## Appeal Decision

**Appeal Ref: APP/T2350/W/18/3209520**

**Croftlands, Broad Meadow, Chipping PR3 2GH**

- The appeal is made under section 78 of the Town and Country Planning Act 1990 against a refusal to grant planning permission.
  - The appeal is made by Ms J and I Seed against the decision of Ribble Valley Borough Council.
  - The application Ref 3/2018/0303, dated 4 April 2018, was refused by notice dated 21 June 2018.
  - The development proposed is the erection of four dwellings (three net new dwellings).
-

SITE PLAN_AS PROPOSED

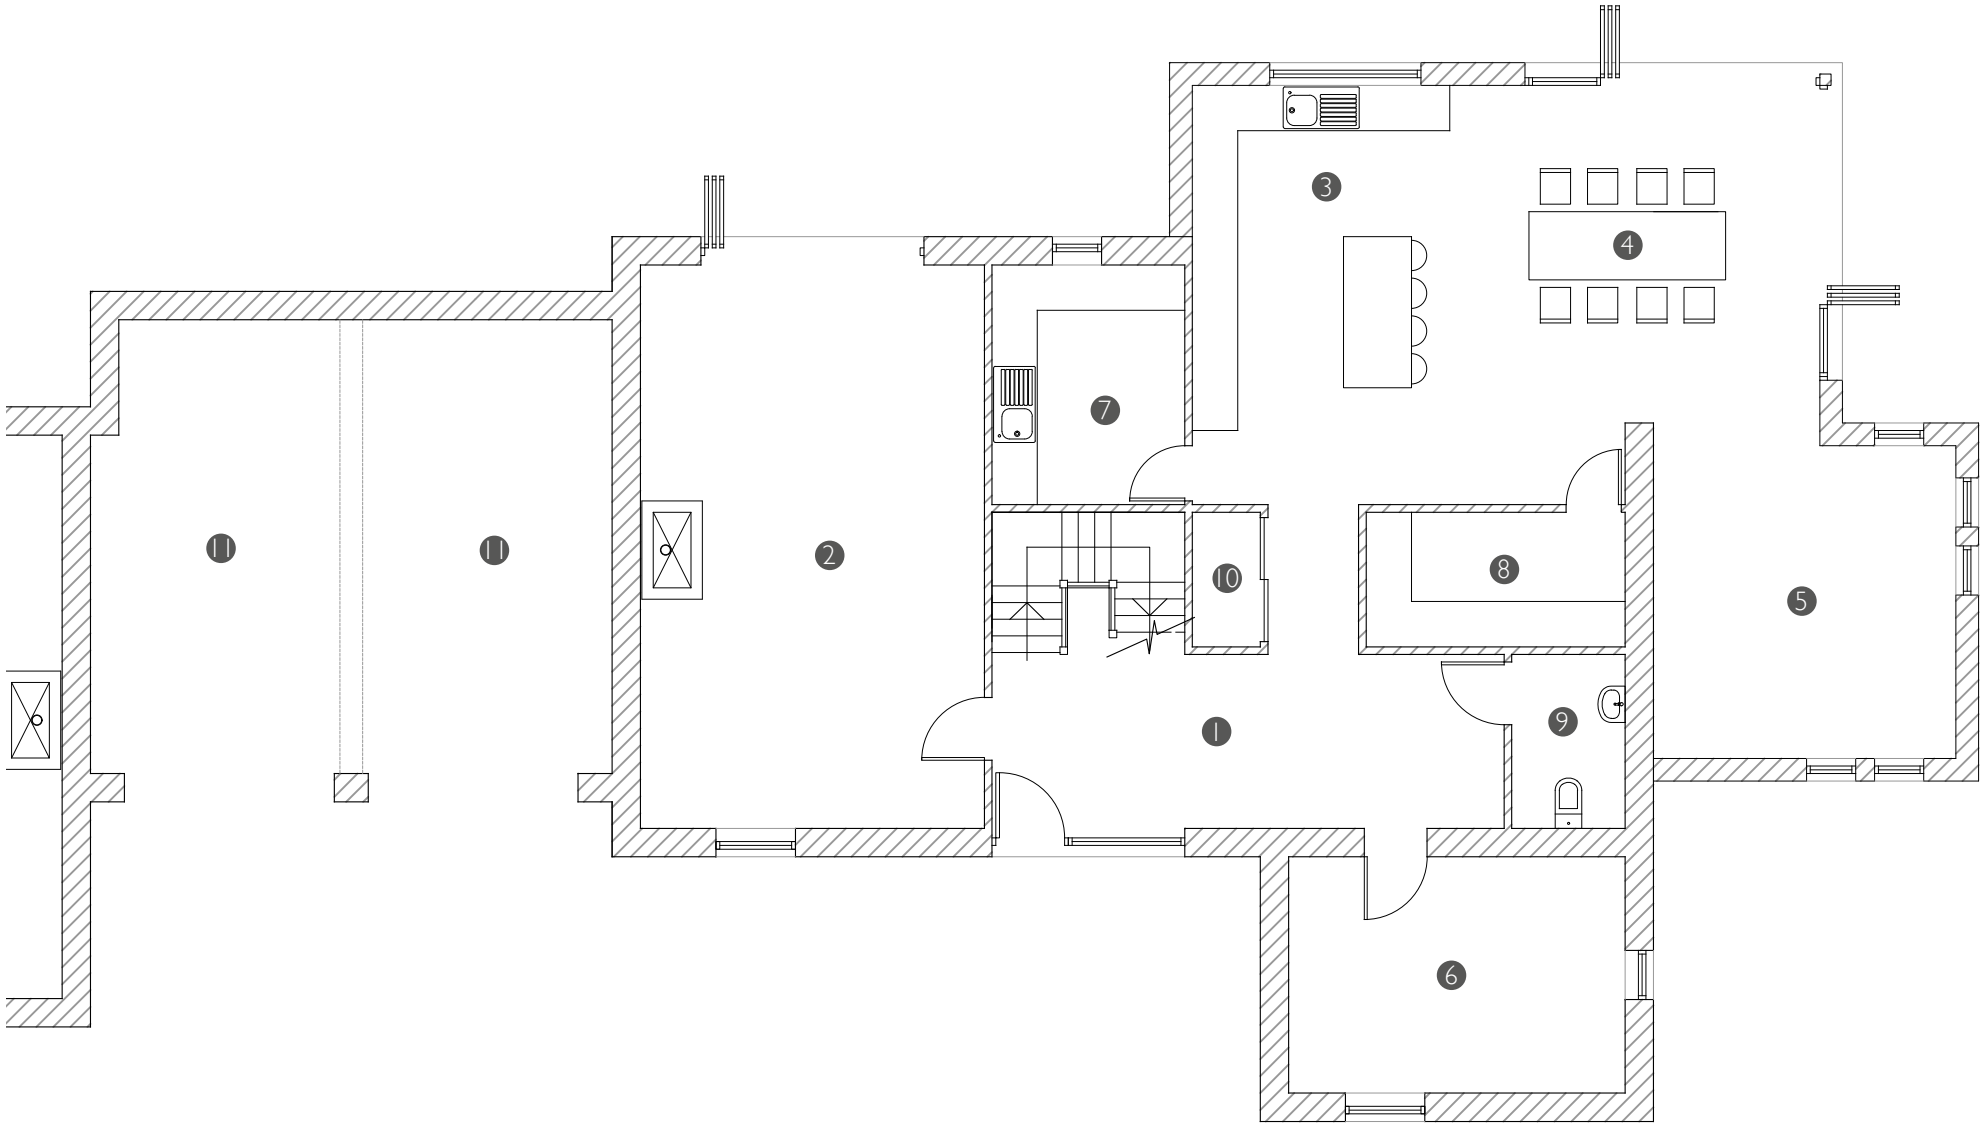
14. Each of the proposed dwellings would be two storeys high and face inwards towards a small cul-de-sac. Plots 1 and 2 would be linked by single storey garages. Plot 3 would have a four bay car port to the south, while plot 4 would be to the west of Croftlands. Garages and carports could allow vehicles to be hidden from view, but future occupants could not be forced to use them to park their vehicles. The proposed dwellings would be of a high-quality design and they would be constructed using traditional building techniques and appropriate materials. Collectively, however, they would introduce a suburban pattern of development of a scale and mass that would not respond to the visual openness of the site and its surroundings. Large curtilages associated with each dwelling and large areas of hardstanding would further affect this. While each dwelling would offer a spacious environment, the removal of permitted development rights would only mitigate the effect of domestic paraphernalia so far. Domestic items such as washing lines, children's play equipment and BBQ's would be inevitable and lead to a suburban character which would be harmful to the landscape and character of the Forest of Bowland AONB.

16. Notwithstanding this, the extant planning permission for the part of the site and the nearby dwellings, the appeal scheme, on the whole, would not protect, conserve or enhance the AONB as the additional dwellings proposed would harm the transition from the settlement to the open rural landscape. I therefore conclude, on this issue, that the proposed development would have a significant effect on the character and appearance of The Forest of Bowland
